PLANNING CONSULTATION RESPONSE

Application No	2026/0641
Proposal	Residential development up to 9 dwellings (Permission in Principle).
Address	Land off Barnsley Road, Darton, Barnsley S75 5NT
Date of Consultation Reply	4 th September 2026
Consultee	Highways DC

Drawing Title.
**SITE PLAN AS
PROPOSED
9NO DWELLINGS**

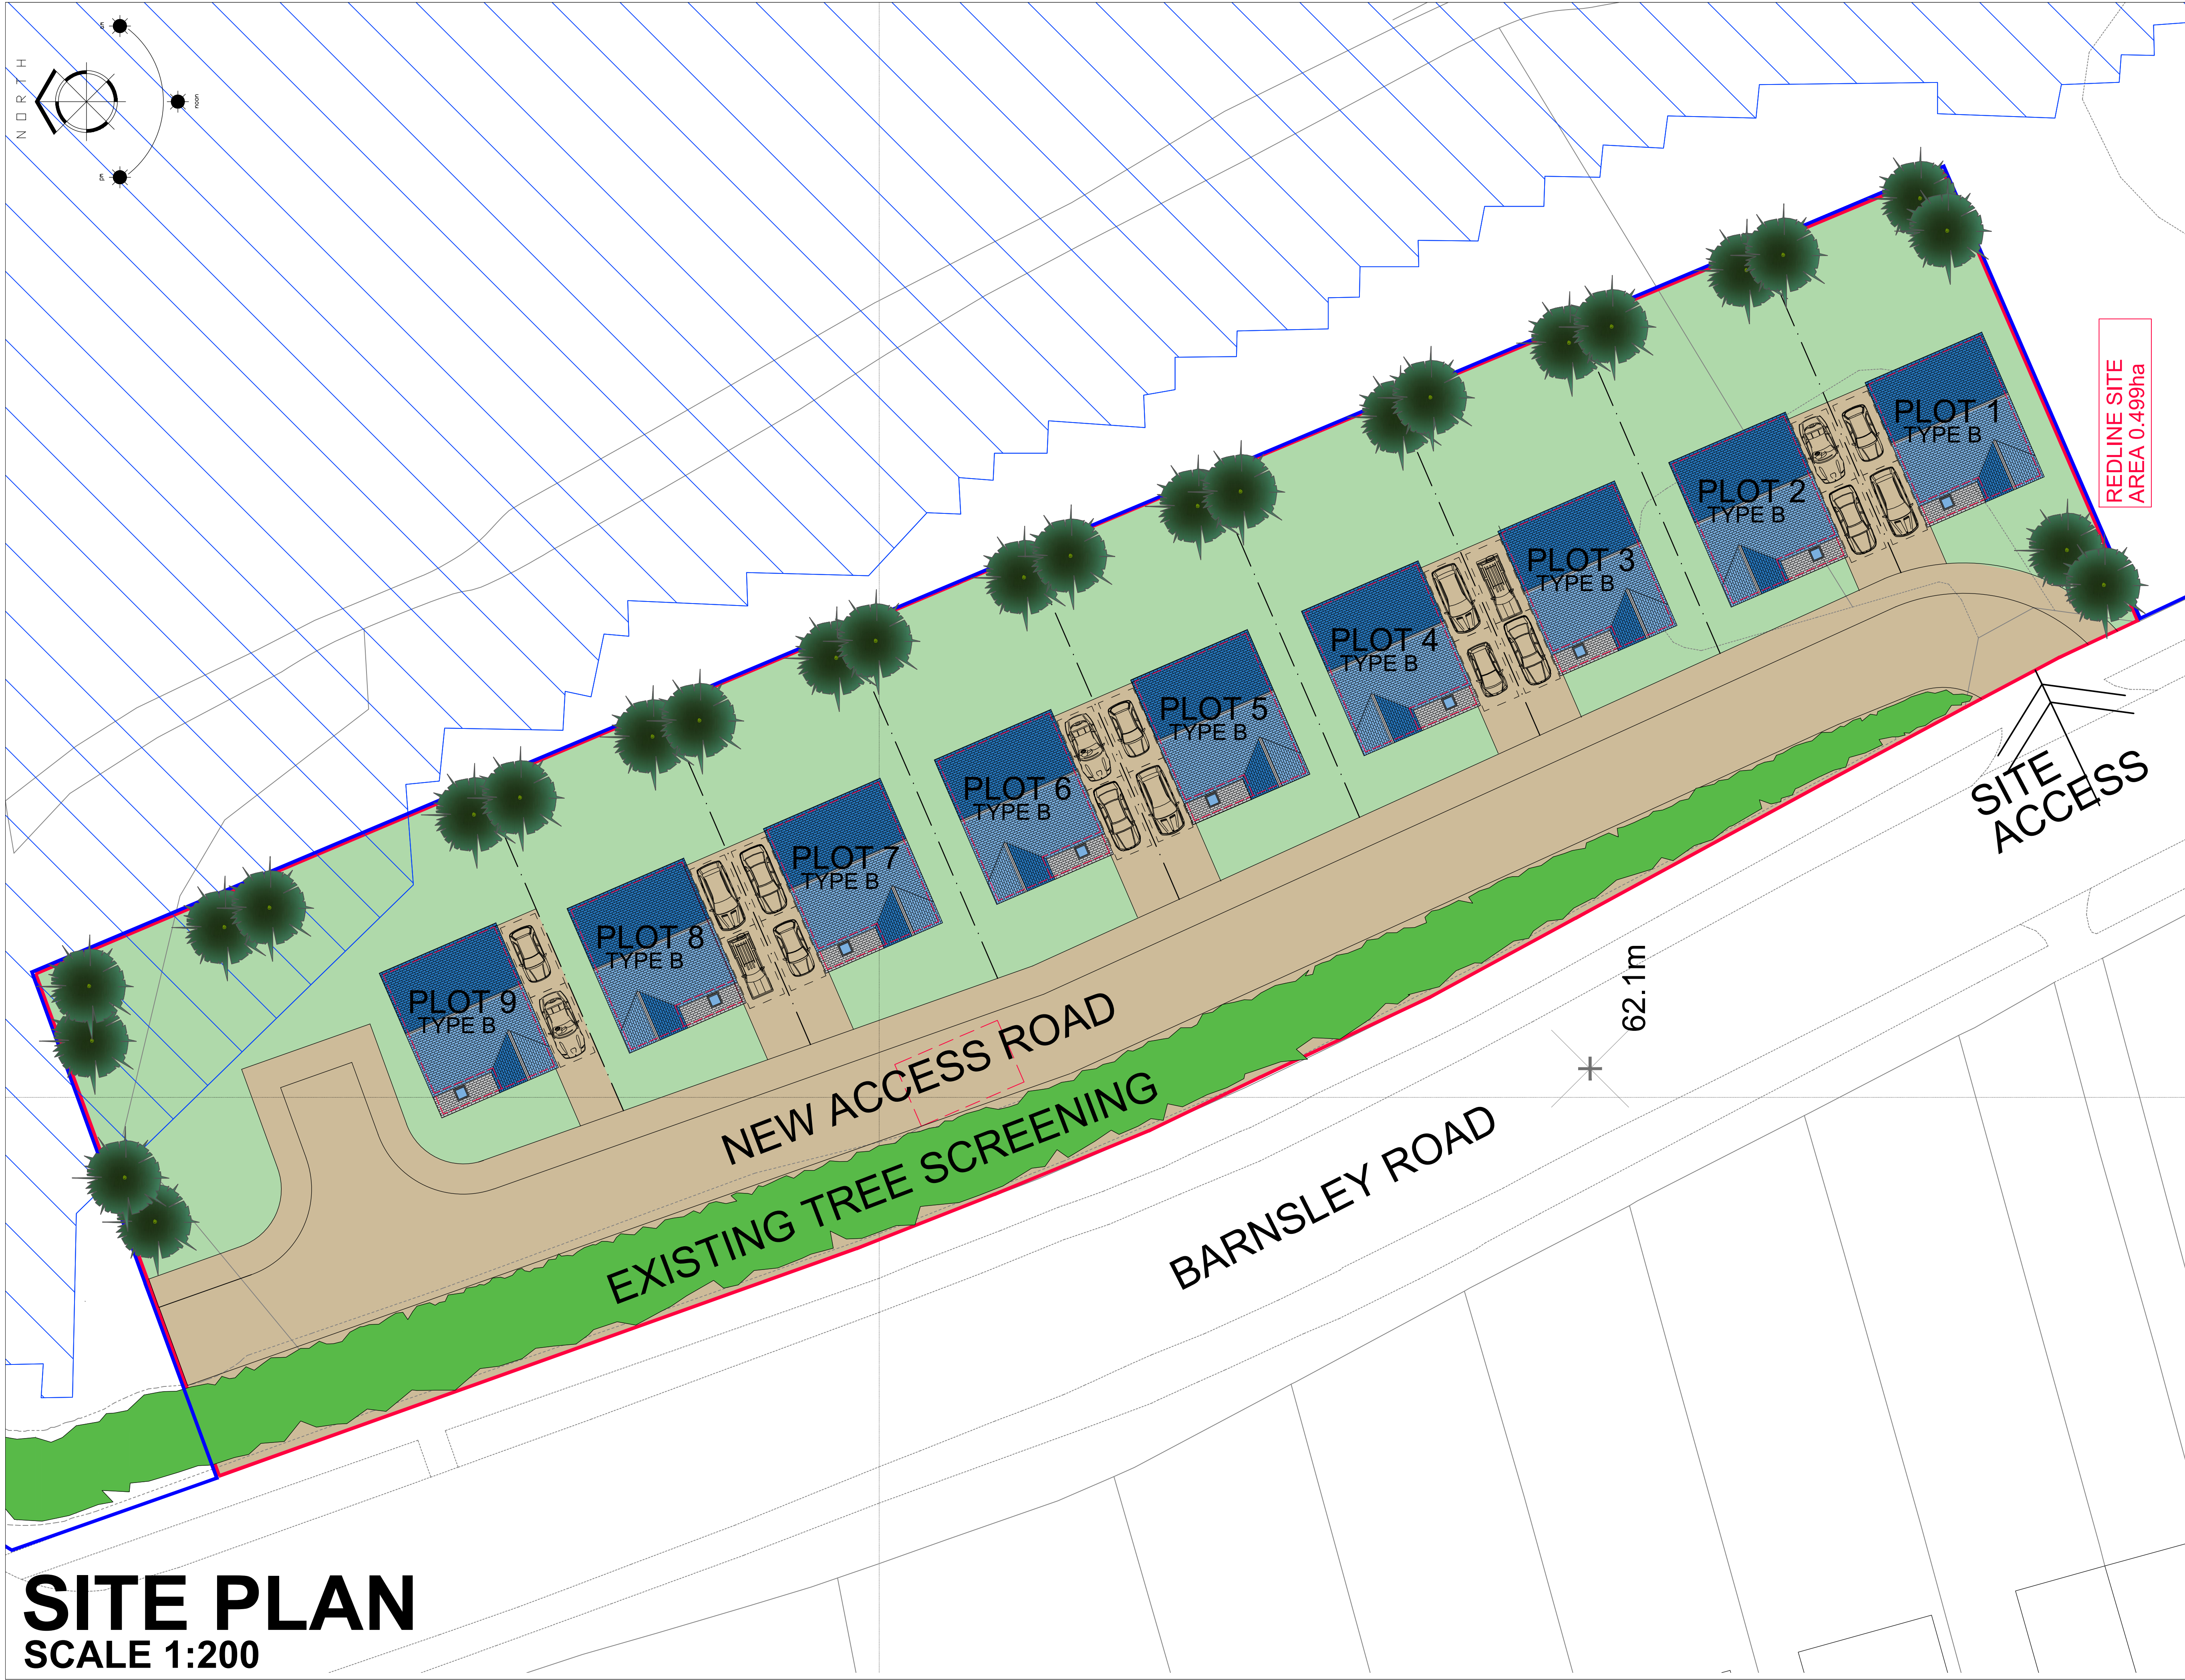
However, there are a number of issues that would need to be addressed in order for full planning permission to be obtained based on the indicative layout submitted:

- The accesses to Plots 1 and 2 are too close to the site access junction with Barnsley Road; there should be no vehicular accesses/driveways within 20m of the junction.

- Minimum sight lines of 2.4m x 120m are required at the site access junction with Barnsley Road; the sight line to the left (South) appears to be achievable but it is unclear whether the sight line to the right (North) can be achieved.

- Swept path manoeuvres of an 11m long refuse vehicle would need to be provided in order to demonstrate that the vehicle can manoeuvre in and out of the site access (to/from both directions) and turn within the site.

- The layout does not include any visitor parking; two spaces should be provided (1 space per 4 dwellings).
 - It is noted that the red line boundary includes part of the public highway. At the north-western area of the site, it appears that the highway boundary extends around 9m beyond the rear of the footway to a point that would be approximately in the middle of the proposed access road. There is an embankment within the site which acts as a retaining structure for Barnsley Road, as such, any future detailed proposals must include plans and information regarding the proposed levels along the access road and any impact that the development may have upon the embankment. It is worth making clear that the protection of the retaining embankment is intrinsic to the proposed development being satisfactory from a highways perspective. Given the design, safety, inspection and maintenance considerations involved and the potential impact on highway users it will be required that the technical approval procedures contained within DMRB CG 300 must be adhered to for all highway structures. The approval procedure is to be followed for the construction or alteration of any highway structure, whether to be adopted or not, with The Technical Approving Authority being the Highway Authority. For information, the definition of a highway structure can fall into one of two types, either:

- Given the proximity of the supporting structure to Barnsley Road, and that if it were to fail would endanger users, if the applicant intends to, for example, cut into the embankment and erect a retaining wall, there will be a need for the applicant to provide design details including a cross section of the wall for consideration by the structures team before determination of the application and subsequent technical approval through the Approval in principle (AIP) procedure.
